**RE: LLFA Response – 6/2020/3222/MAJ, Former Volkswagen Van Centre, Comet Way, Hatfield, AL10 9TF**

**1. LLFA comment – Updated Modelling**

### **2. LLFA comment – Clarification of the submitted surface water drainage.**

Stantec Drawing 47179/4001/002 Surface Water Drainage Strategy

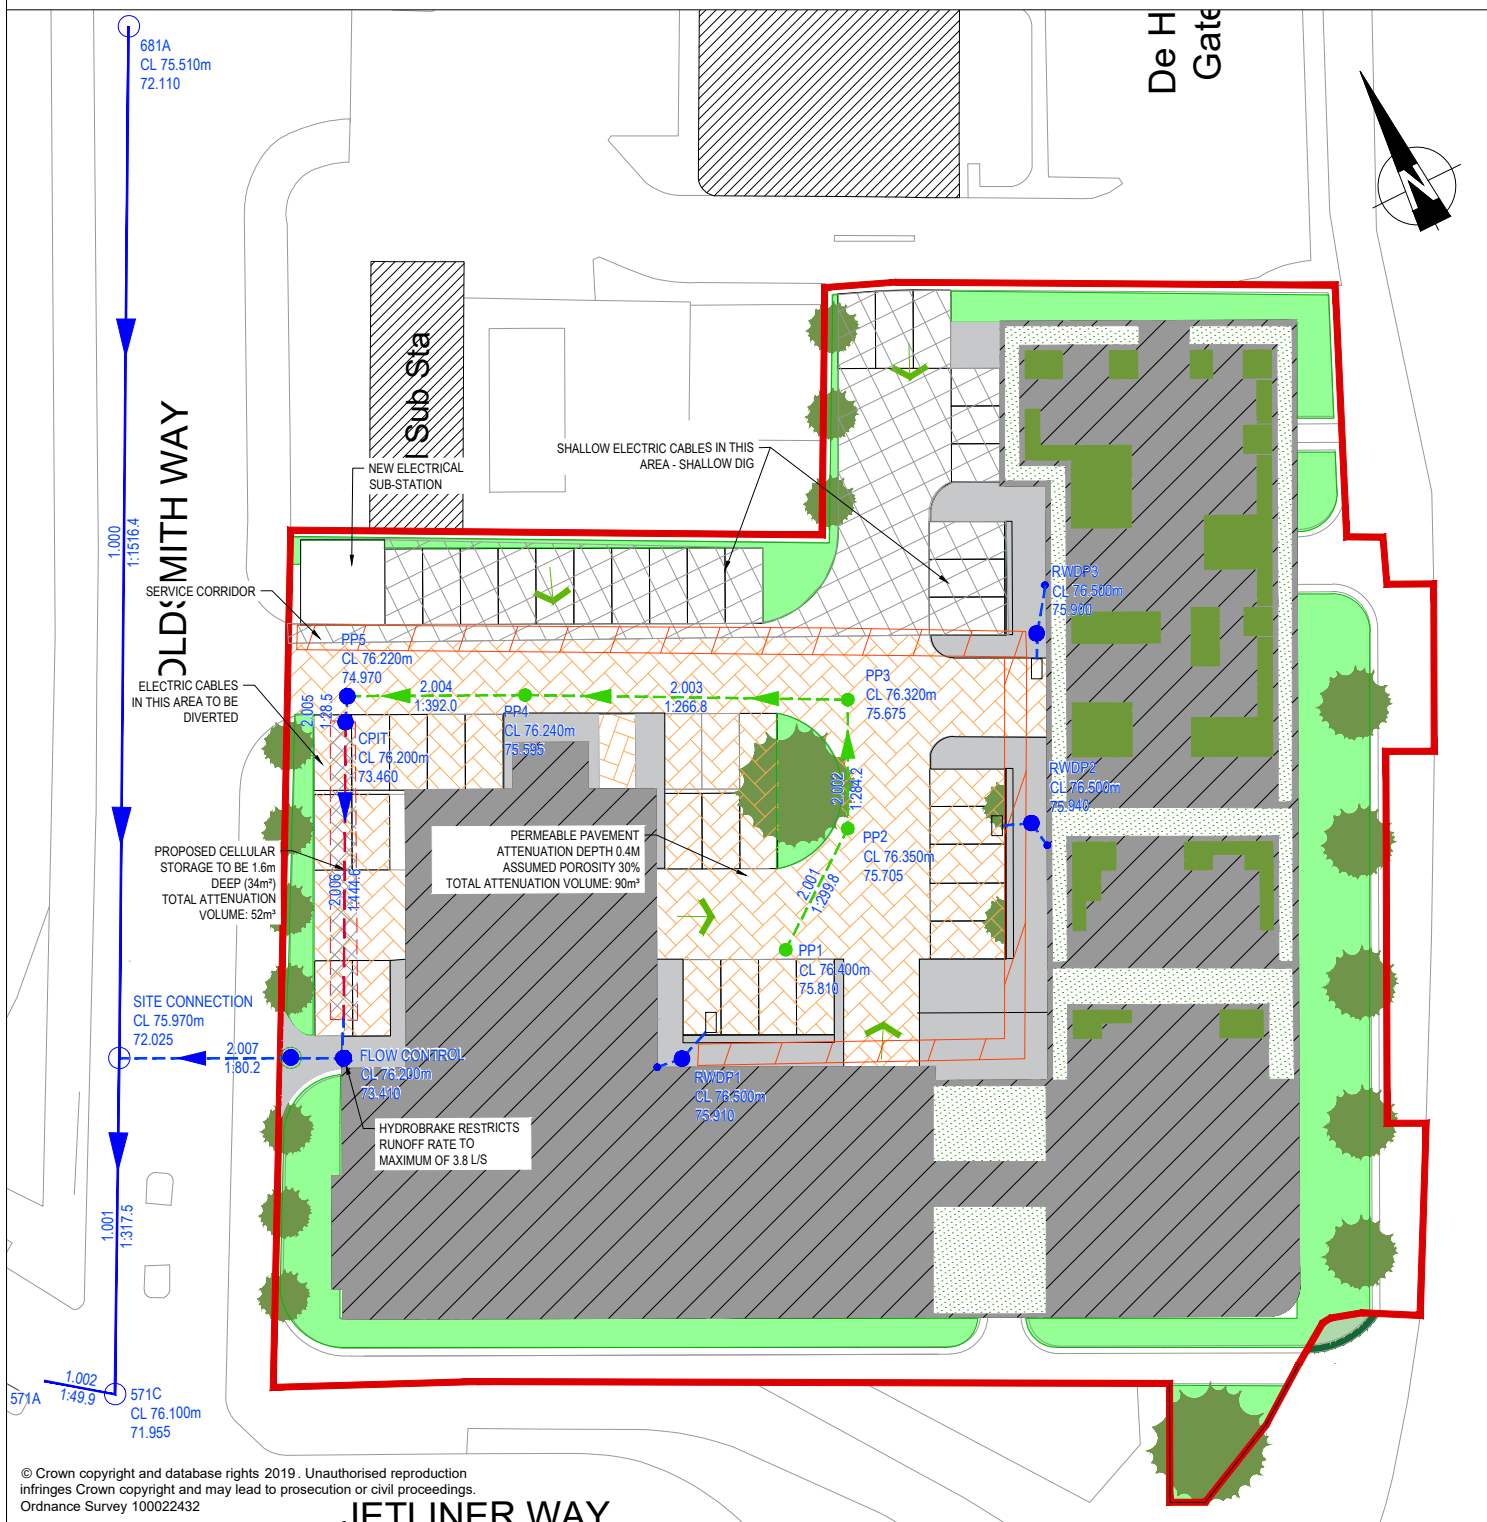
*“We note that some of car parking areas, located outside of the building footprint, will be provided with permeable paving with sub-base. However, there are some parking spaces where these structures cannot be provided. Therefore, the applicant should clarify how surface water from those areas will be captured and treated prior to reaching the piped network.*

*Moreover, it should be clarified and identify on a plan how the rest of undercroft parking will be drained, as no information has been provided.*

*On the submitted drainage plan the proposed depth of the cellular storage does not match with the cross section drawing included. We would advise this should be consistent and the layout plan should be updated. In addition, depth of permeable paving sub-base structure should be also clarified.*

The car parking impermeable areas on the site will drain to the adjacent lined porous paving areas. Our drainage strategy drawing has been updated and attached to make this clearer. Our post development calculations had included these impermeable areas and showed this can operate as shown.

We acknowledge the undercroft parking drainage was not referenced in the drainage statement as this will form part of the internal building drainage and services design. However, we do acknowledge that some minimal rainwater egress may occur from the entrance of vehicles and in the winter, snow accumulation from cars also needs to be considered. The drainage for this area will likely discharge to the foul sewer. The development proposals were issued as part of the pre-application request to Thames Water and an assumption made on the potential overall rate applicable to the foul drainage for the site. No objection was raised by Thames Water; however, to ensure this will be captured at the detail design stage reference has been made to this on the updated drainage strategy drawing.

There was an error in tank depth made on the drainage section shown on the surface water drainage strategy drawing, this should be 1.6m depth, this has been updated. Depth of porous paving sub-base from our calculations is also referenced on the updated drainage drawing.
